OAKLANDS FARM SOLAR PARK

Appendix 6.1 – Consultation Responses

Document Ref: EN010122/APP/6.1/Appx 6.1

Appendix 6.1 - Ecology Consultation Responses

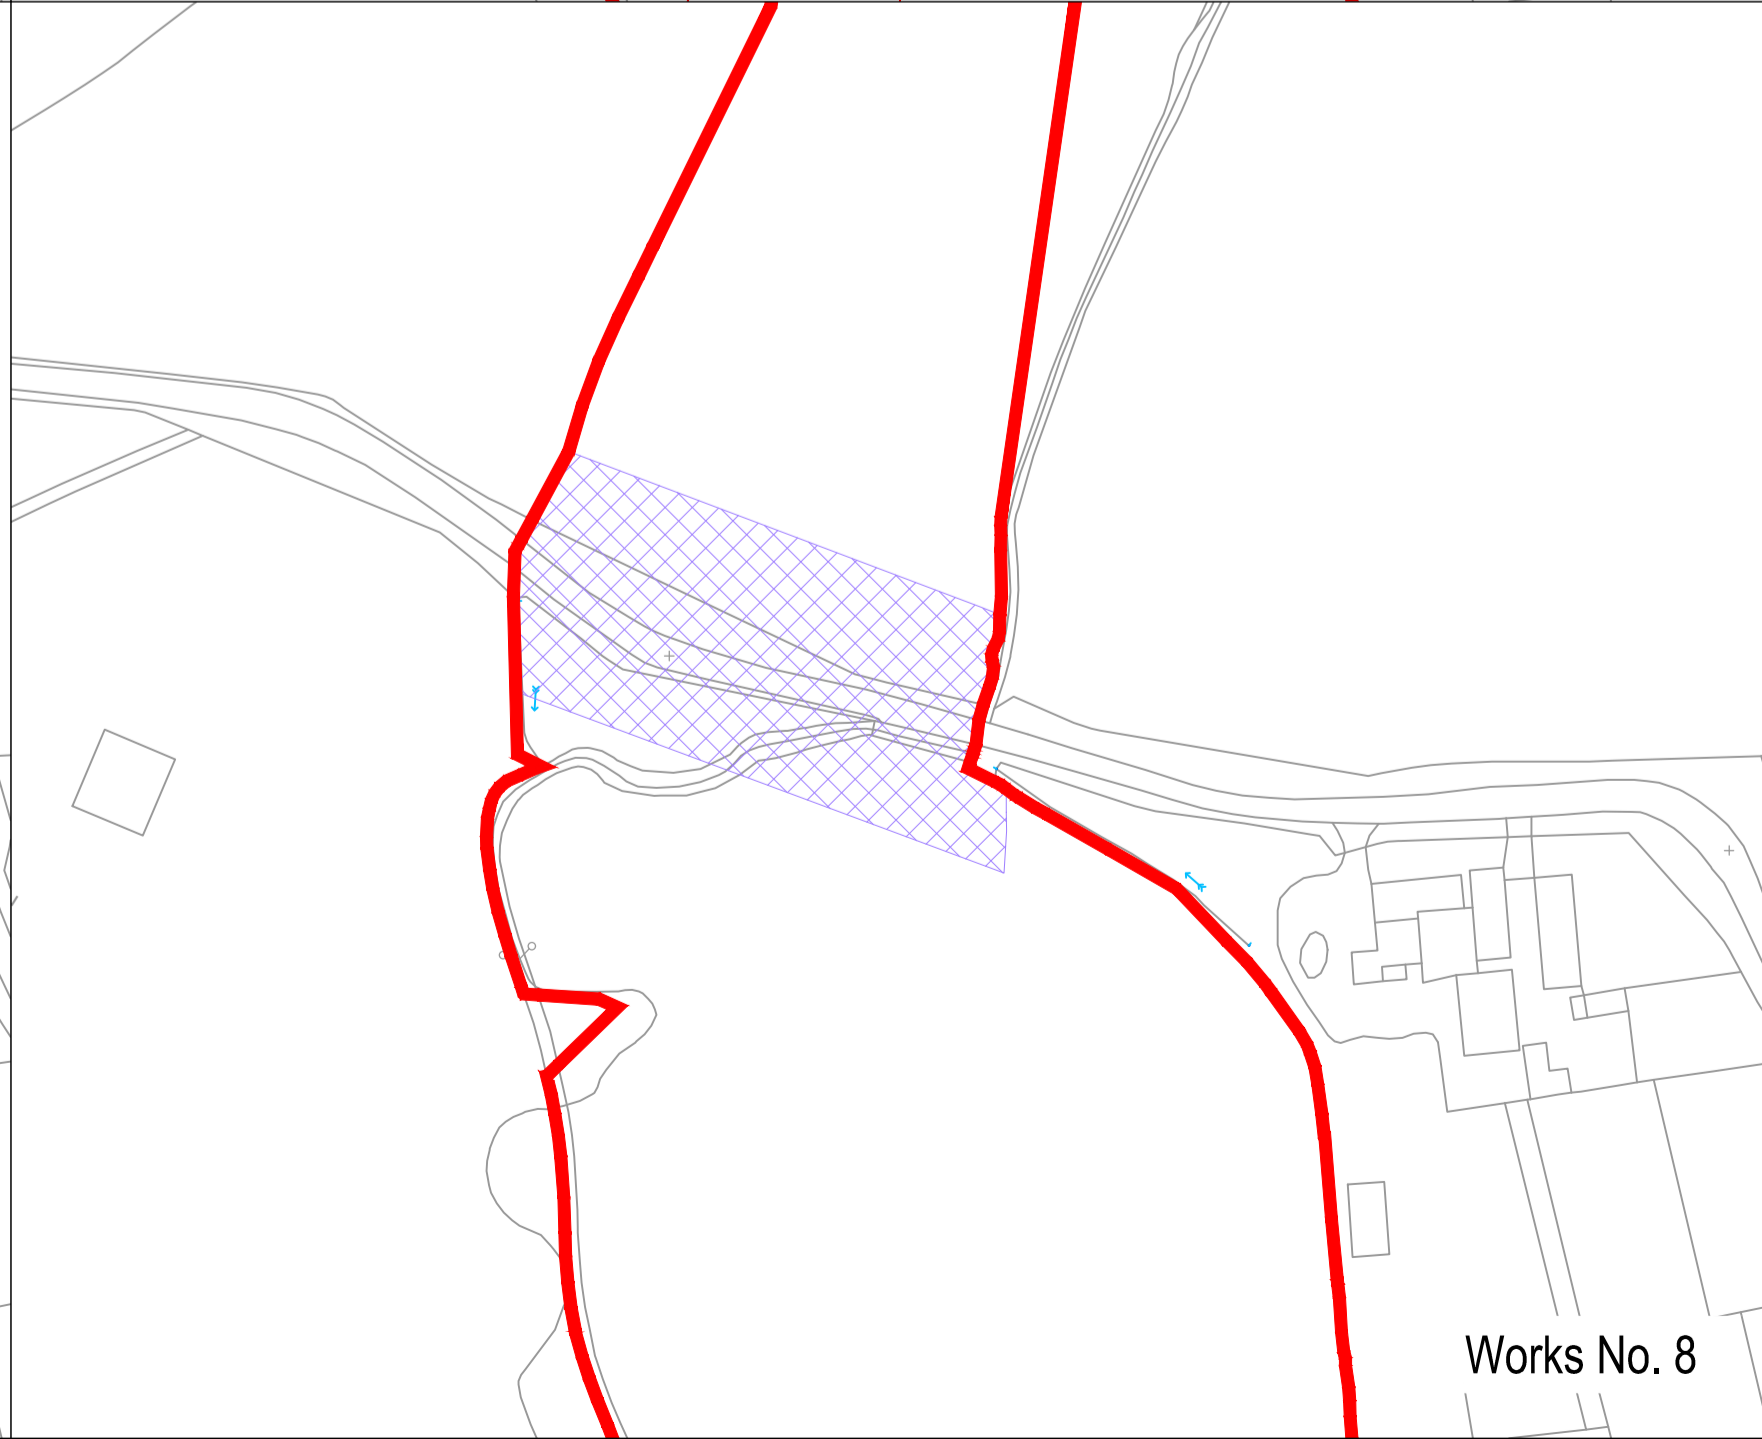
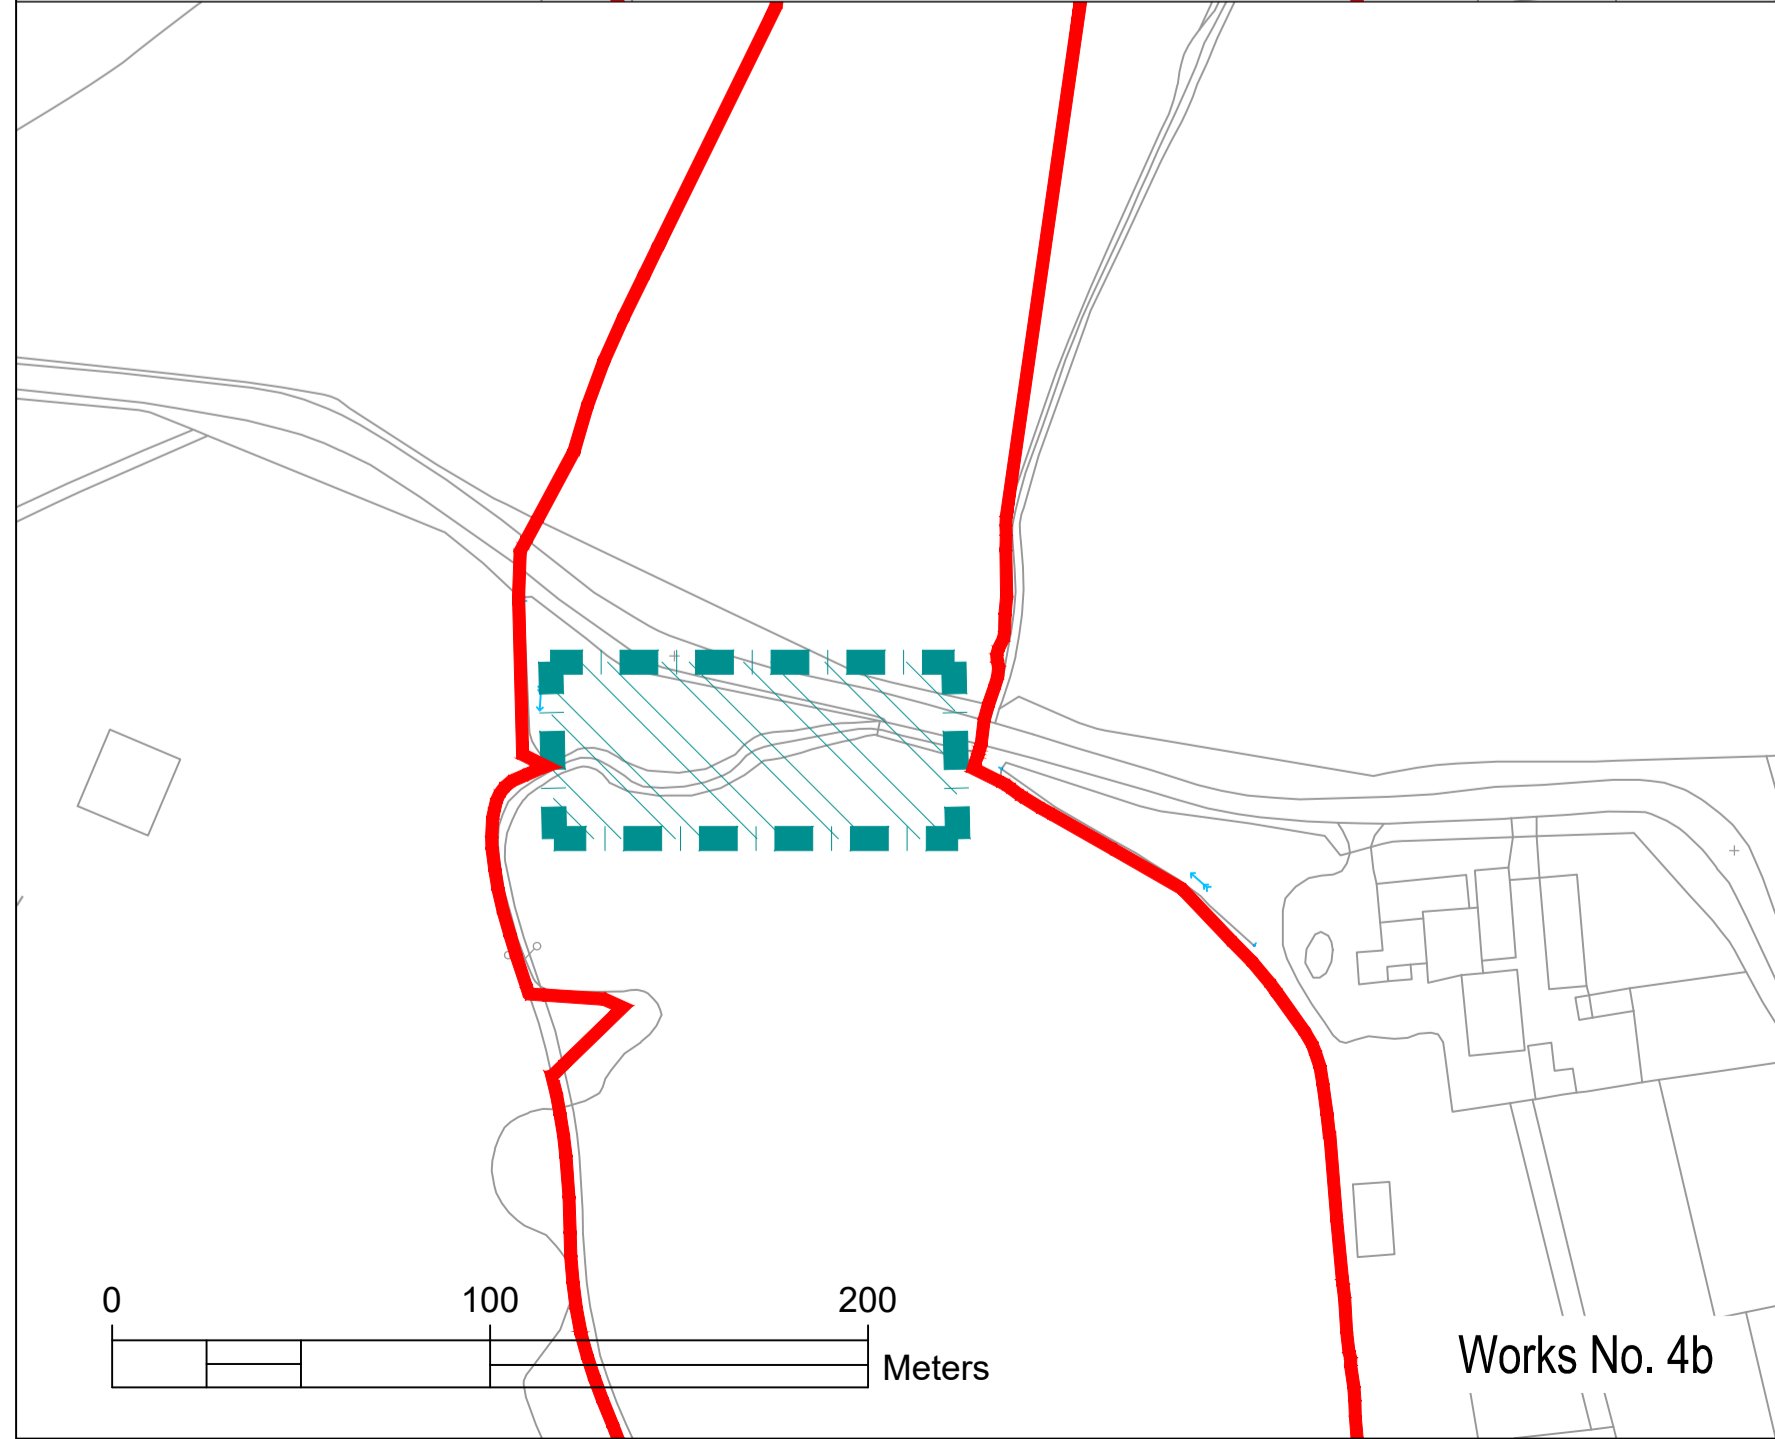
<p>The ES should clarify the location and specification of badger access gaps within the perimeter fencing, which should ideally be plotted on an approved site plan.</p>	<p>Mammal gaps will be provided in the fencing at specific locations. Indicative locations are shown as detailed in Figure 6.3. This will allow the movement of small mammals, including badger and hedgehog to disperse through the site.</p>
<p>South Derbyshire</p>	<p>Additional comments were received from the SBBC Biodiversity Officer:</p>	<p>The ES Chapter has included additional provision of information on protected and notable species, including barn owl, GCN and skylark. It has been</p>
